**WELWYN HATFIELD BOROUGH COUNCIL
DIRECTORATE OF STRATEGY AND DEVELOPMENT**

DELEGATED APPLICATION

Application No: 6/2016/1812/HOUSE
Location: 5 Thornton Road, Little Heath, Potters Bar, EN6 1JJ
Proposal: Erection of ground floor side and rear extension
Officer: Mr A Mangham

6/2016/1812/HOUSE

| 475/3 | |

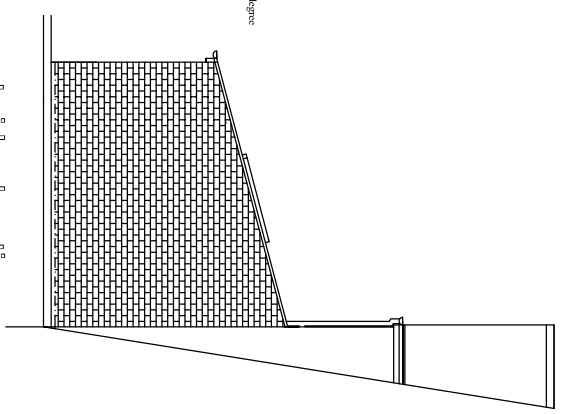
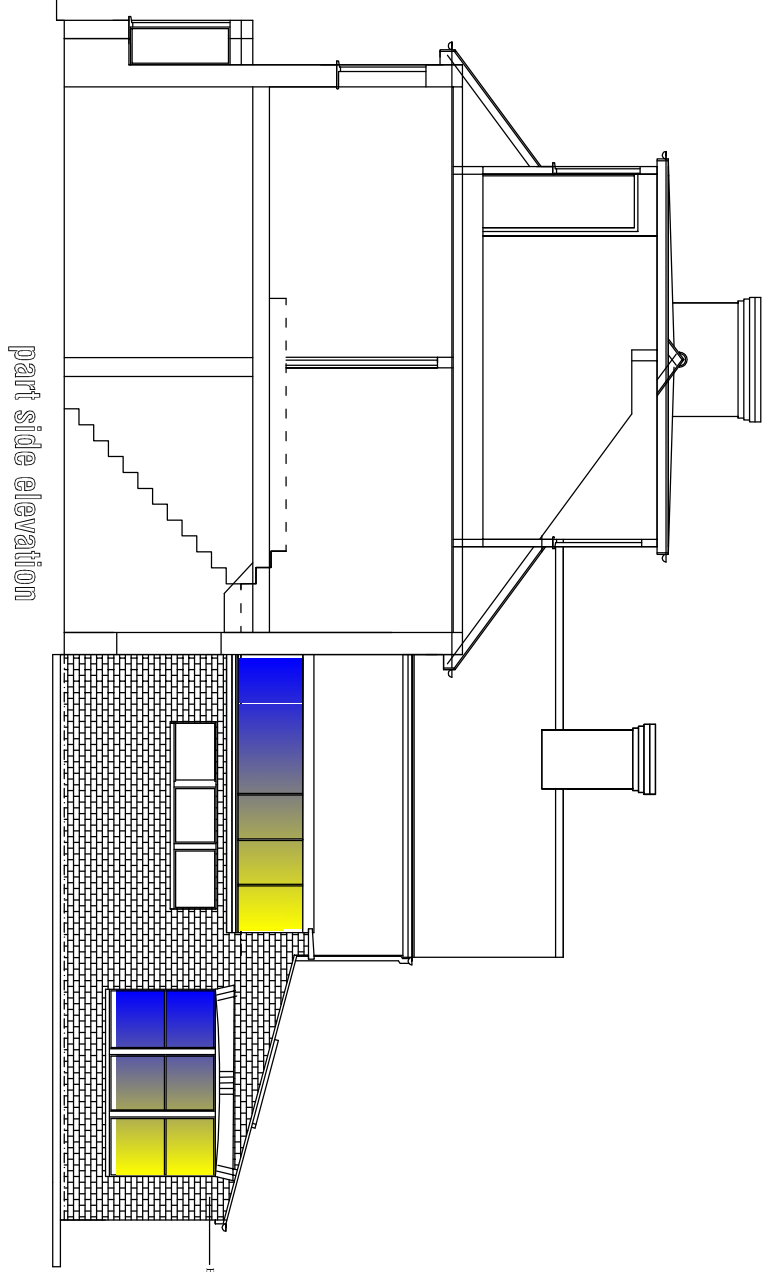
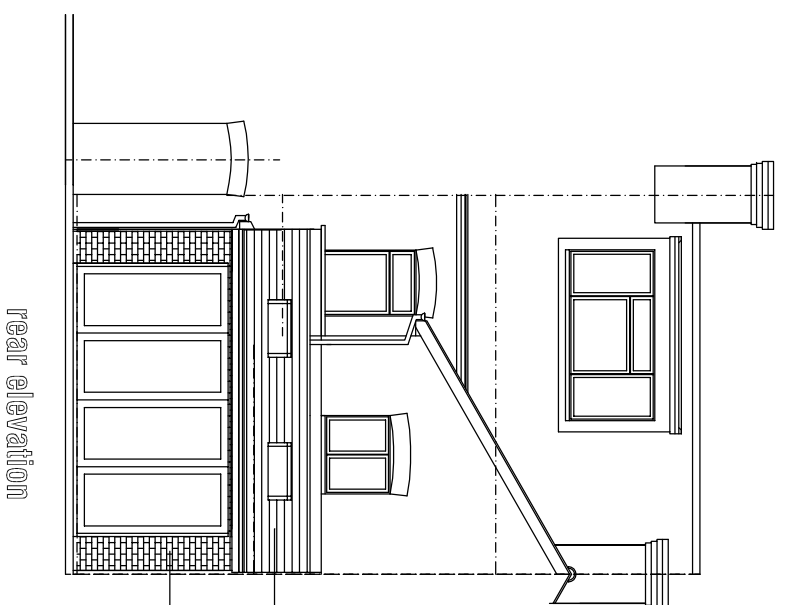
This application seeks planning permission for the erection of ground floor side and rear extension, to be constructed of facing brickwork. This is considered to complement and reflect the existing dwelling, maintaining the existing character and appearance. It would be reasonable to attach a condition that the brickwork used in the existing dwelling match those proposed in the extension. Given its rear sitting, and having regard to the terraced situation, it would not be readily visible from the streetscene and therefore is considered to maintain the character and appearance of the streetscene and surrounding area.

With this in mind, the full brick wall to elevation facing No.3 Thornton Road will safeguard potential issues of loss of privacy and overlooking. Turning to the potential for loss of day/sun/sky light and as to whether it is overbearing, it is concluded that by virtue of its single storey form, maximum 3.5m rear projection and lean-to roof configuration no detrimental impact will result in terms of any impact on their living conditions.

Turning to the impact on No.7 Thornton Road, the existing mature landscaping and boundary wall detail in the immediate area of the extension and its associated windows will also safeguard potential issues of loss of privacy and overlooking. It is also noted that this property already has a similar extended structure in the form of a conservatory on their rear elevation. It is also of note is that the nearest windows in the proposed extension will actually be high level designs. This will remove the opportunity or any sense of overlooking between the two properties, in particular the habitable kitchen window opposite at No.7.

conditions to secure obscure glazing and high level windows are not justified.

2. The brickwork, roof tile, bond, mortar, detailing, guttering, soffits and other external decorations of the approved extension/alterations must match the existing dwelling/building in relation to colour and texture.
